Charlotte Department of Transportation

Memorandum

Subject: Rezoning Petition 08-090: Located on the southeast corner of West Arrowood Road and Sandy Porter Road (revised 6/20/08)

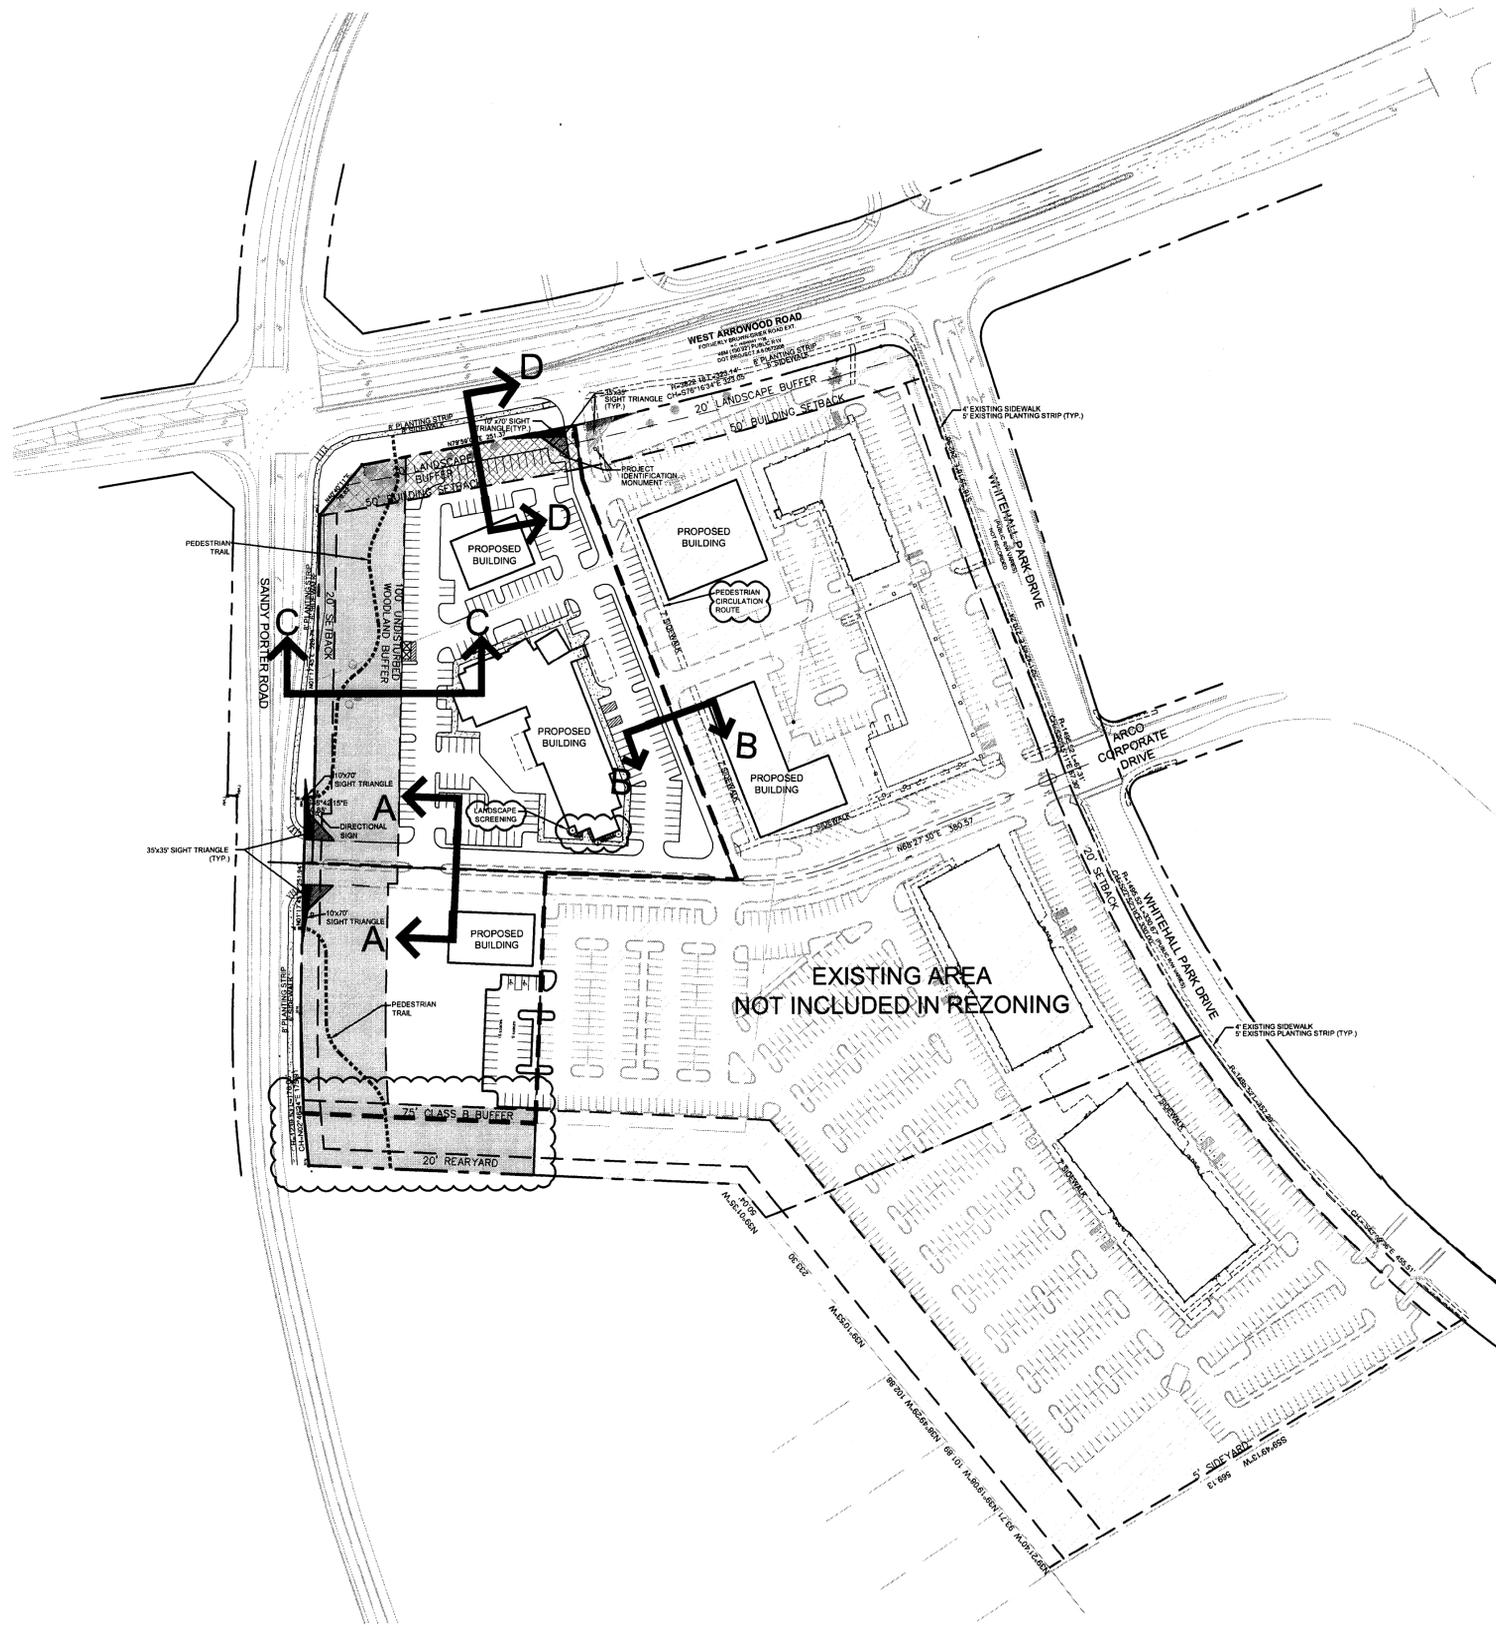
1. The developer needs to provide an 8' sidewalk with 8' planting strip along West Arrowood Road. The wider sidewalk will facilitate an overland connector requested by Mecklenburg County Park and Recreation. (*Previous Review Comment-2*)
2. The developer needs to provide a 5' sidewalk with 8' planting strip along the proposed private street internal to the site. A note needs to be added to the site plan to indicate that this private street will not be gated and remain open/unrestricted for public use 24 hours each day, 7 days each week.

3. Arrowood Road is a major thoroughfare requiring a minimum of 100 feet of right-of-way. The developer/petitioner should convey right-of-way in fee simple title to meet this requirement, measuring 50 feet from the centerline of the roadway.
4. Sandy Porter Road is a minor thoroughfare requiring a minimum of 70 feet of right-of-way. The developer/petitioner should convey right-of-way in fee simple title to meet this requirement, measuring 35 feet from the centerline of the roadway.
